Application for Planning Permission for Works or Extension to a Dwelling

Development: Erection of single storey rear extension including the installation 2 x rear balconies and side rooflight and alterations to fenestration.
(This application may affect the character and appearance of the Arundel Conservation Area).

Location: 31 Tarrant Wharf Arundel BN18 9NY

DRAWING TITLE
SITE LOCATION PLAN AND
BLOCK PLAN

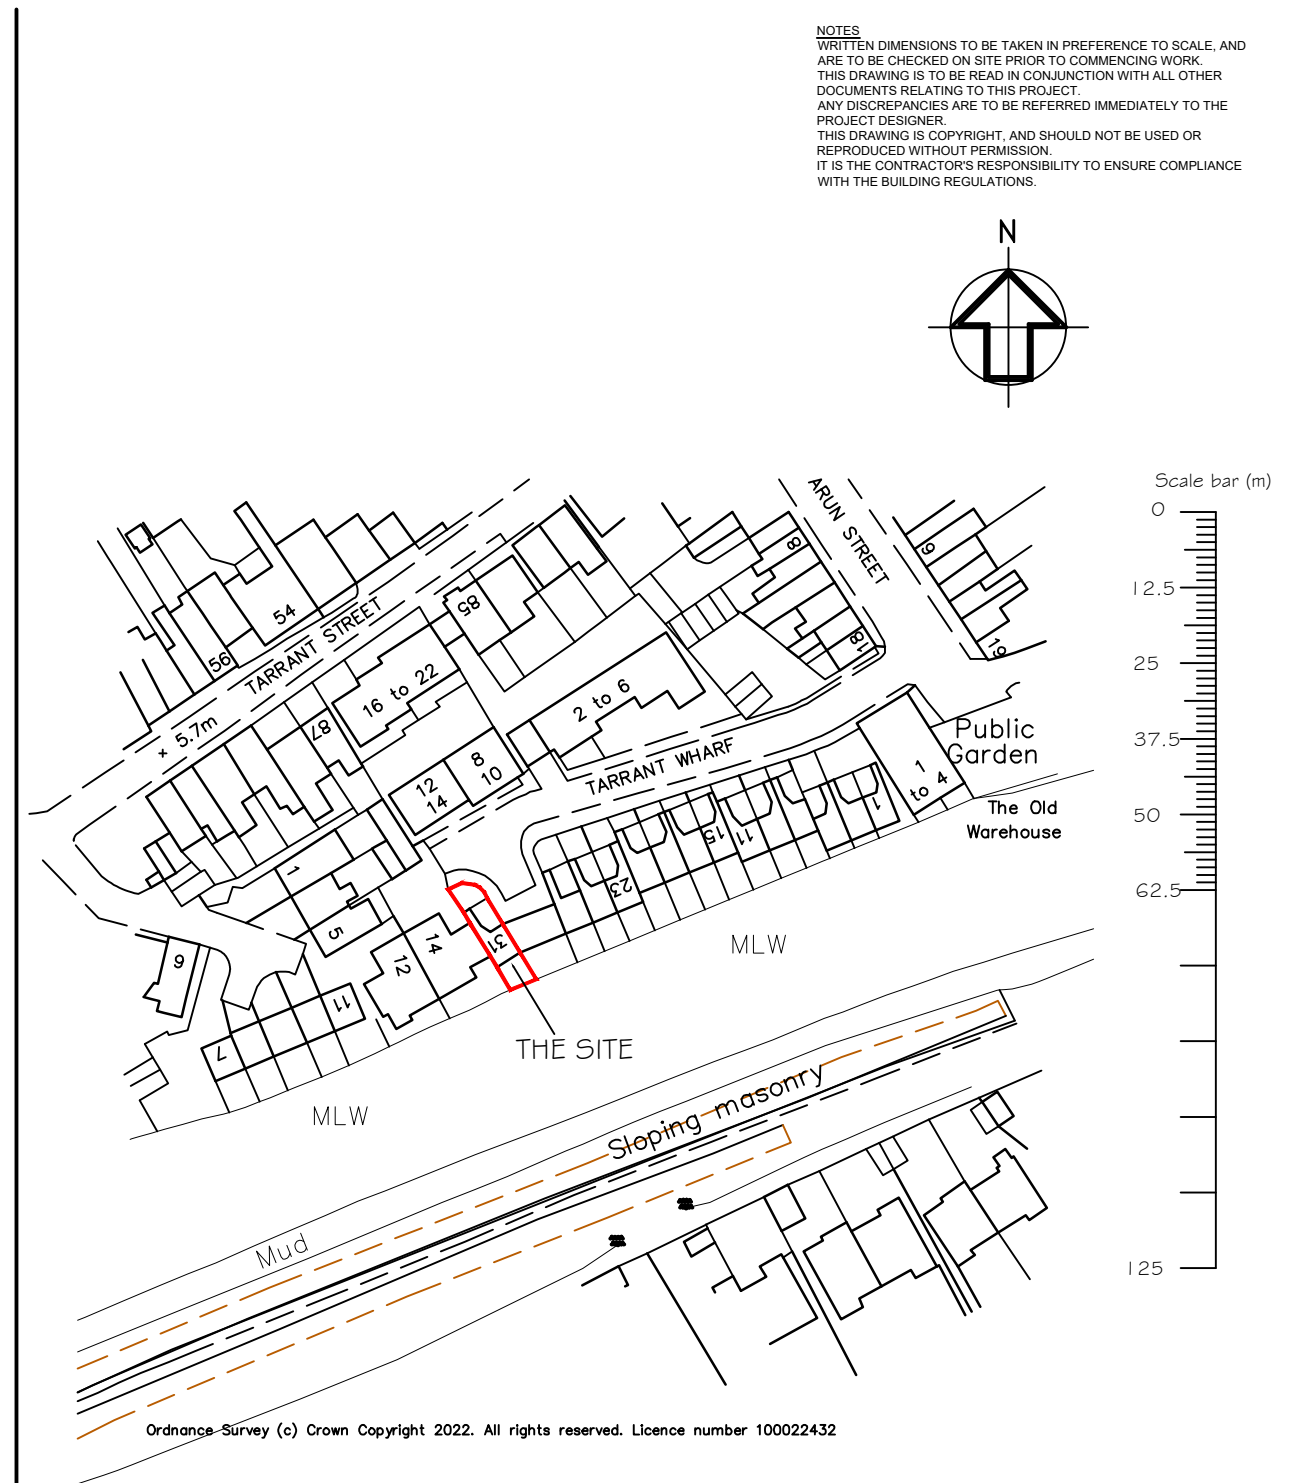
Block Plan

You are required to have dimensions from the proposed extension(s) to all site boundaries. Please amend.
